## PLANNING CONSULTATION RESPONSE

<b>Application No</b>	2025/0775
<b>Proposal</b>	Development of 4 residential dwellings, landscaping and associated infrastructure
<b>Address</b>	Land east of Bank View, Bower Hill Road, Oxspring, Sheffield, S36 8YA
<b>Date of Consultation Reply</b>	18/12/2025
<b>Consultee</b>	Highways Development Control

PROPOSED SITE PLAN

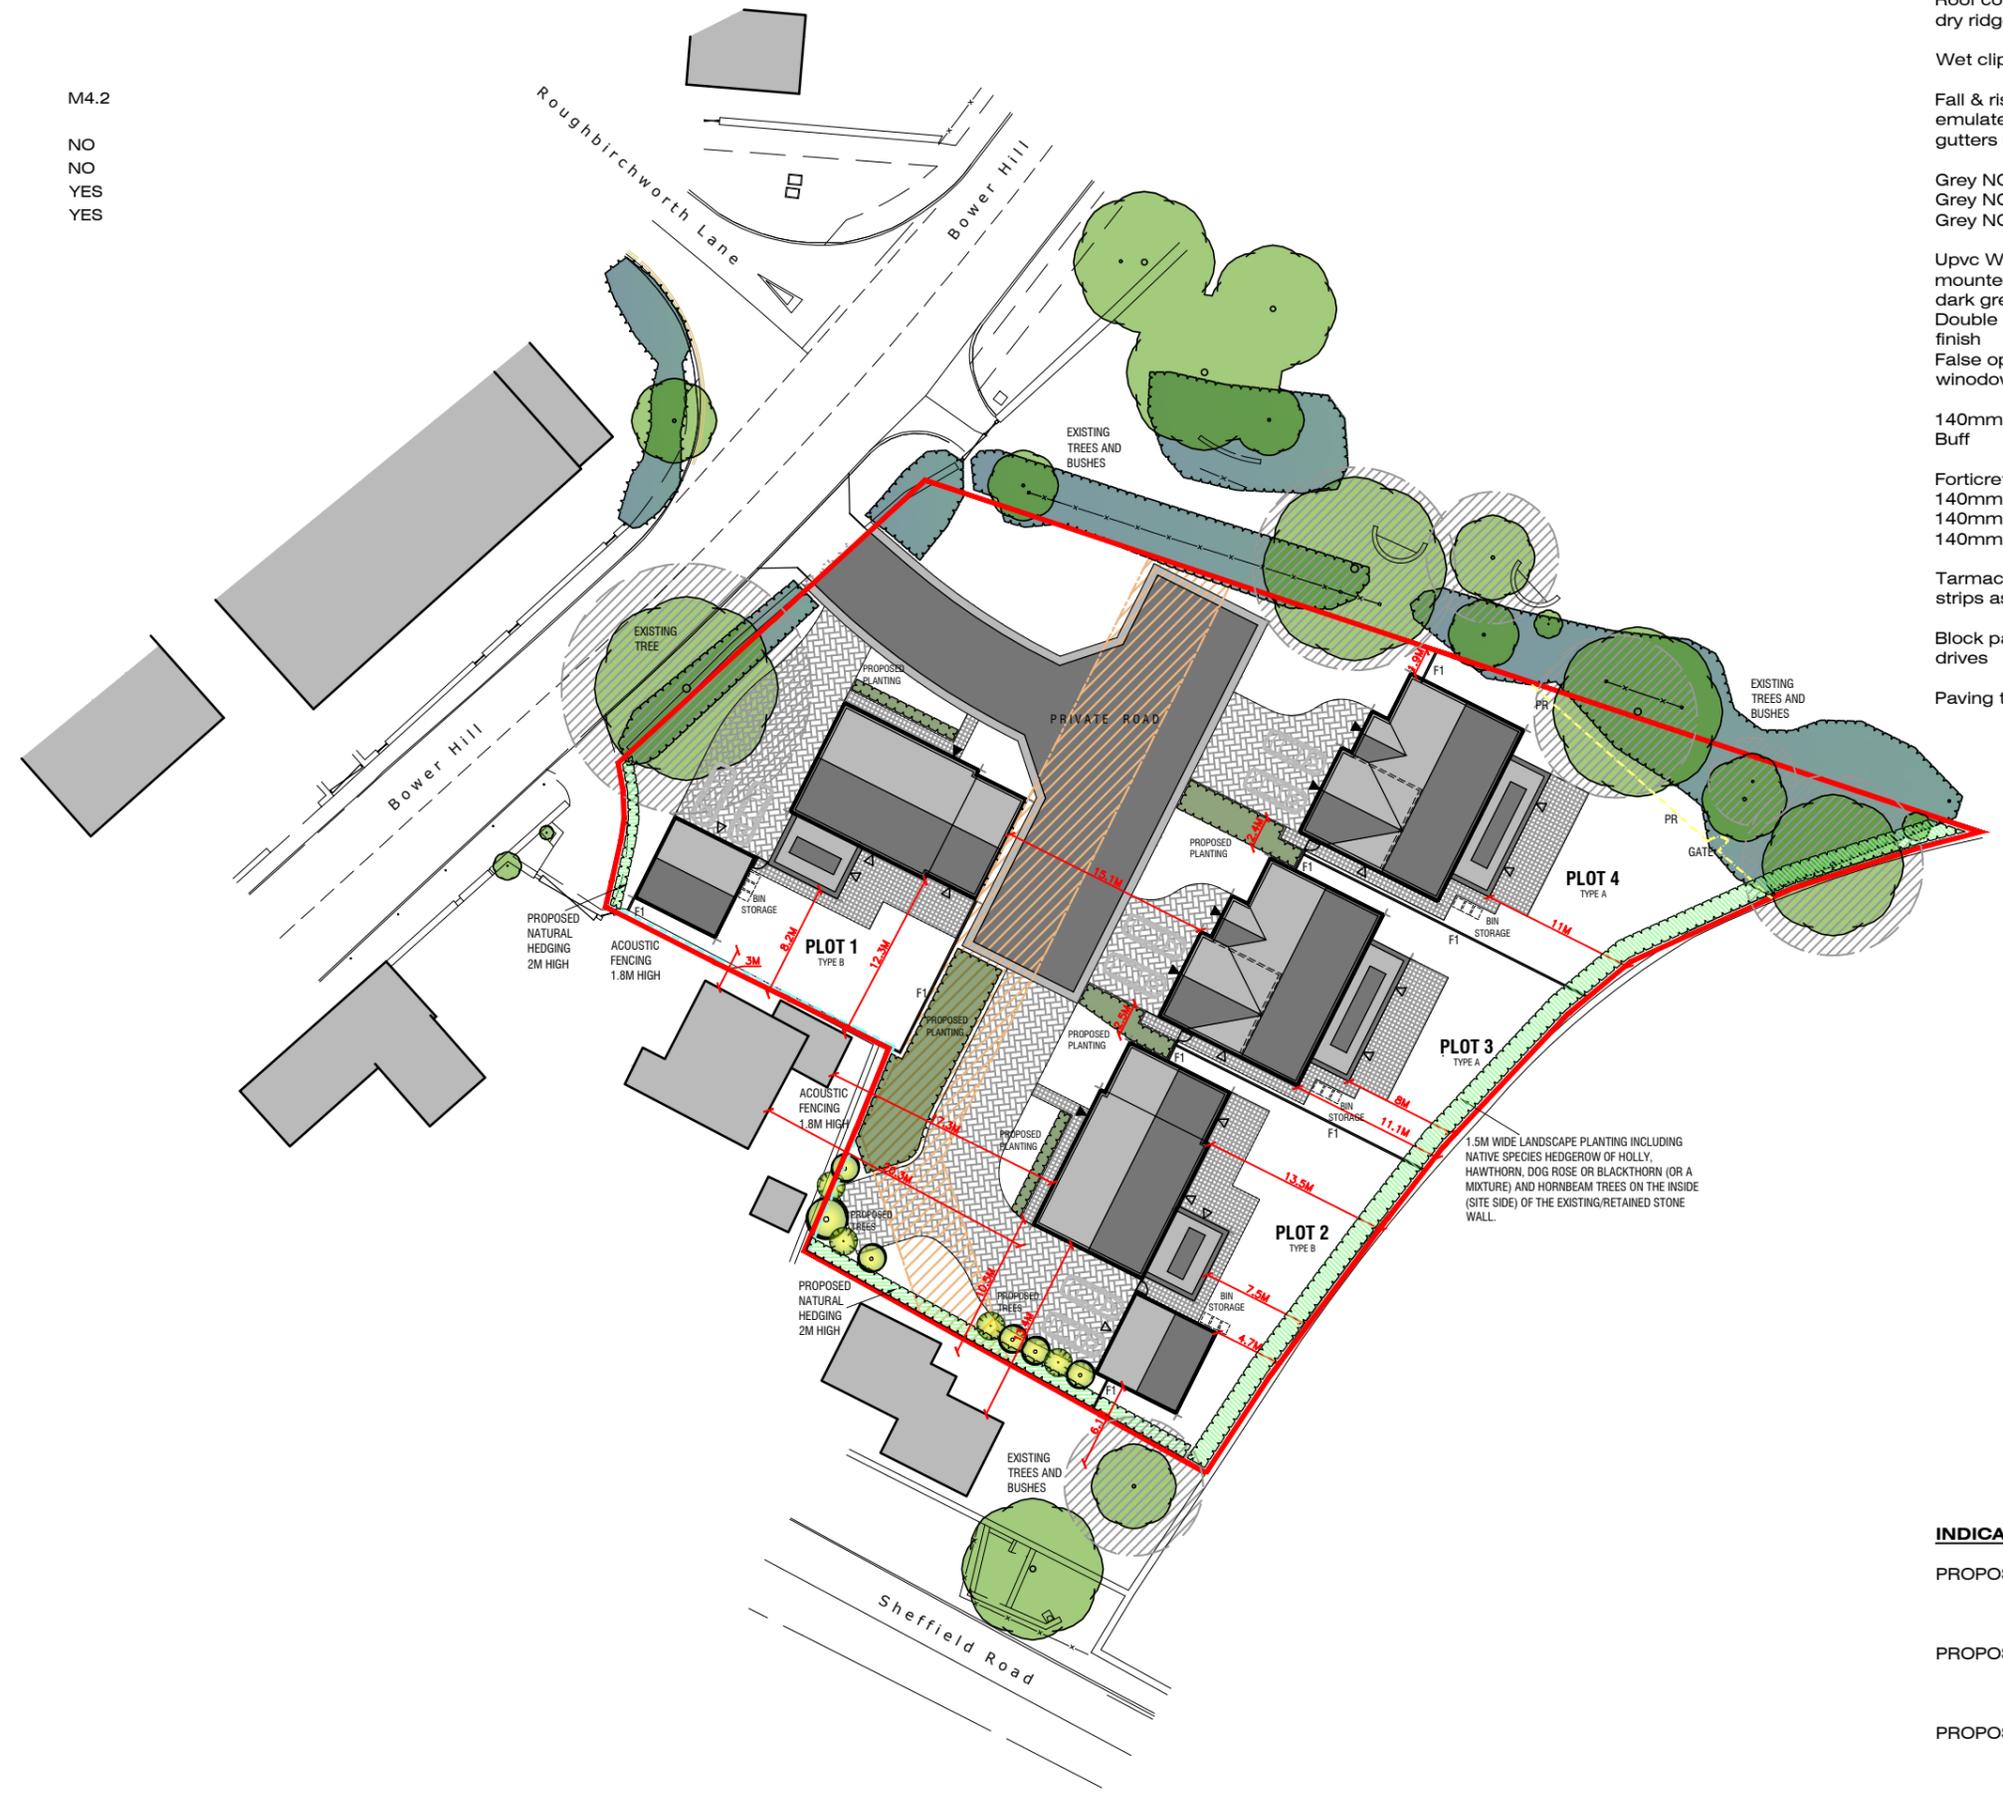
Following on from my previous response, and the subsequent response from AMA, whilst I note the concerns in relation to the existing tree and the impacts that footway construction may have, that is not my primary concern and I would rather that the provision of a pedestrian connection to the south of this site is prioritised over the retention of the existing tree, however I am mindful that this may not be the case for the tree officer, should they have been consulted and appreciate that a balanced view will need to be taken from a planning point of view. That being said, there is no expectation for the footway to extend along the entirety of Bower Hill to the junction with Sheffield Road, and I would be happy with a short section of footway which could potentially avoid affecting the existing Tree, providing a satisfactory crossing point can be constructed, which would provide a much needed connection to the south.

With regards to the concerns raised in relation to potential on street parking for existing residents, I can see that a number of the properties that are referred to actually have rear parking which alleviates this concern somewhat. Furthermore, it is not unusual to have a pedestrian crossing on roads with no parking restrictions.

Should it become apparent during the detailed engineering stages that this southern connection cannot be implemented, then I would suggest that improvements are continued to the northern side of the development with dropped kerbs and tactile paving added to the existing provision as shown below.

As such, I have reworded the condition in relation to offsite highway works to remove the specific requirement of the southern provision but to ensure that some provision is provided.

Notwithstanding the details indicated on the submitted drawings, no works shall commence on site until a detailed scheme for off-site highway works has been submitted to and approved in writing by the Local Planning Authority. This scheme shall include provision for safe pedestrian crossing facilities, which may comprise a footway and crossing point along the site frontage, or, where this is not feasible, the provision of dropped kerbs and tactile paving at an alternative location agreed with the Local Planning Authority, to ensure safe pedestrian access to and from the development.
